**Question**

Knockkillaree, Aughnanure,  
Oughterard, Co. Galway, H91 R25W.

ED25/22

Case file ABP-322245-25

SIDE ELEVATIONS 1:100

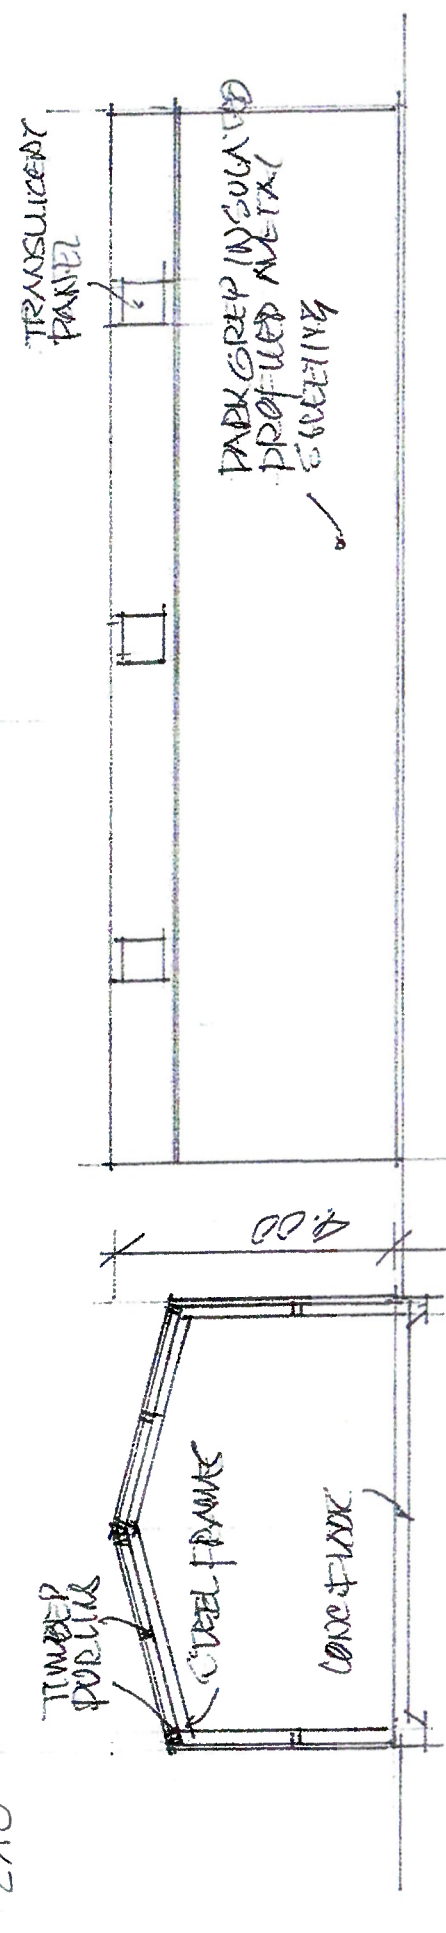
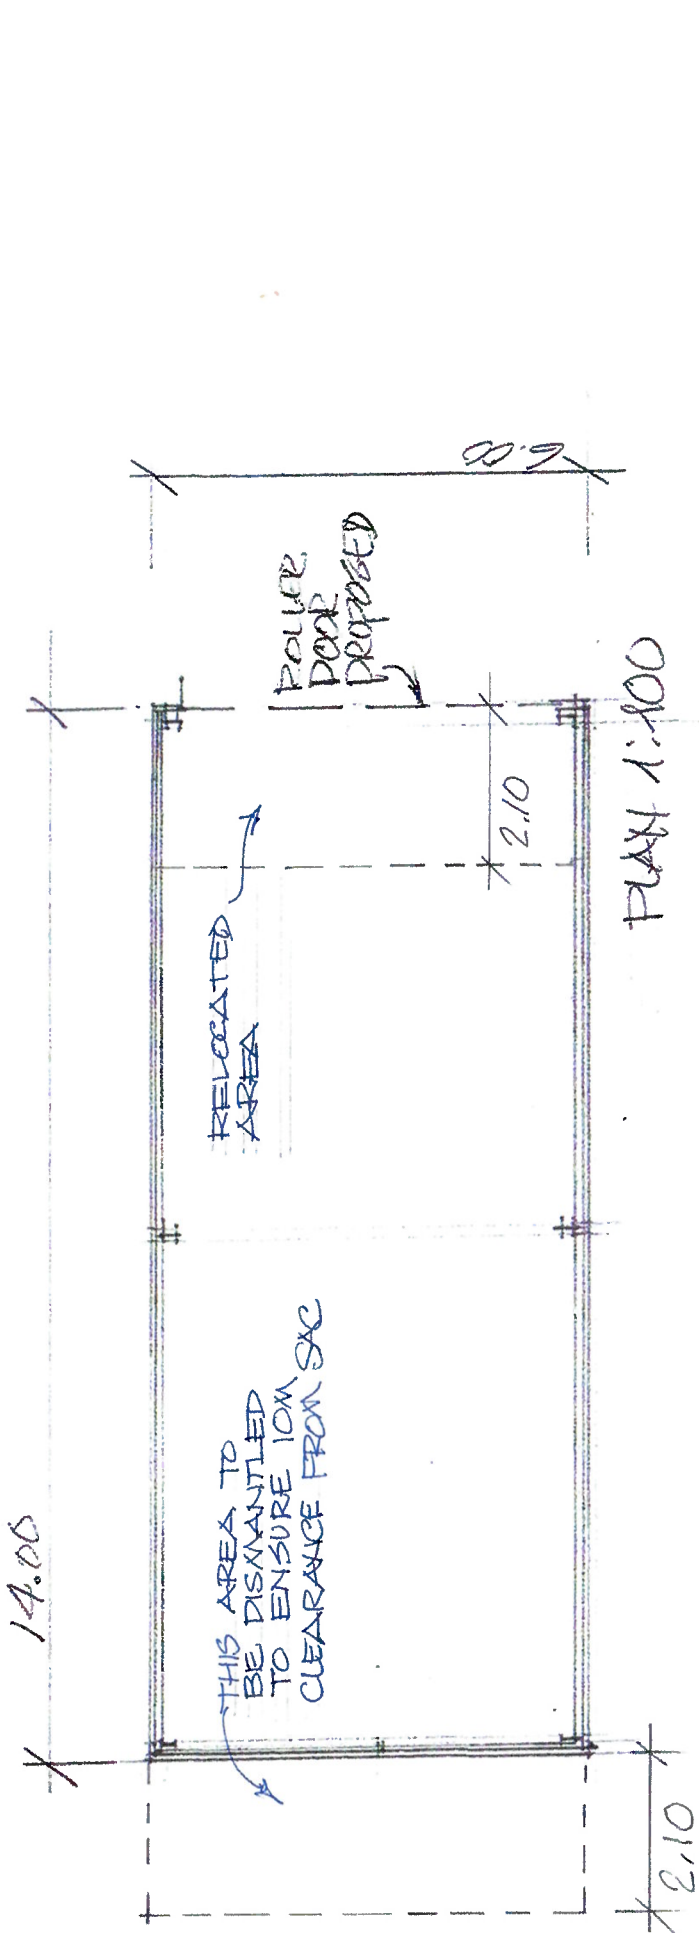
- 9.1.3. The referral submission to ACP includes a 1:100 scaled drawing illustrating the layout of the shed structure the subject of this referral application. I note from the submitted drawing that the shed structure has a floor area of approximately 74 sq. metres and a maximum height of 4 metres above ground level. The submitted drawing indicates that the shed's elevation is comprised of dark green insulated profiled metal sheeting. The proposal also provides for the dismantling of 2.1m section of the eastern portion of the shed structure to ensure a recommended 10m distance from the adjacent watercourse which borders the Lough Corrib SAC (site code 000297) and relocating the dismantled section to the western side of the shed structure.

- 9.3.8. I note that the referrer proposes alterations to include the dismantling of a 2.1m section from eastern gable of the structure and attaching the dismantled section to

the western gable of the temporary structure. I would consider that these alterations are minor in scale and the alterations would have a negligible impact on the overall landscape and the 'Iconic Landscape'.
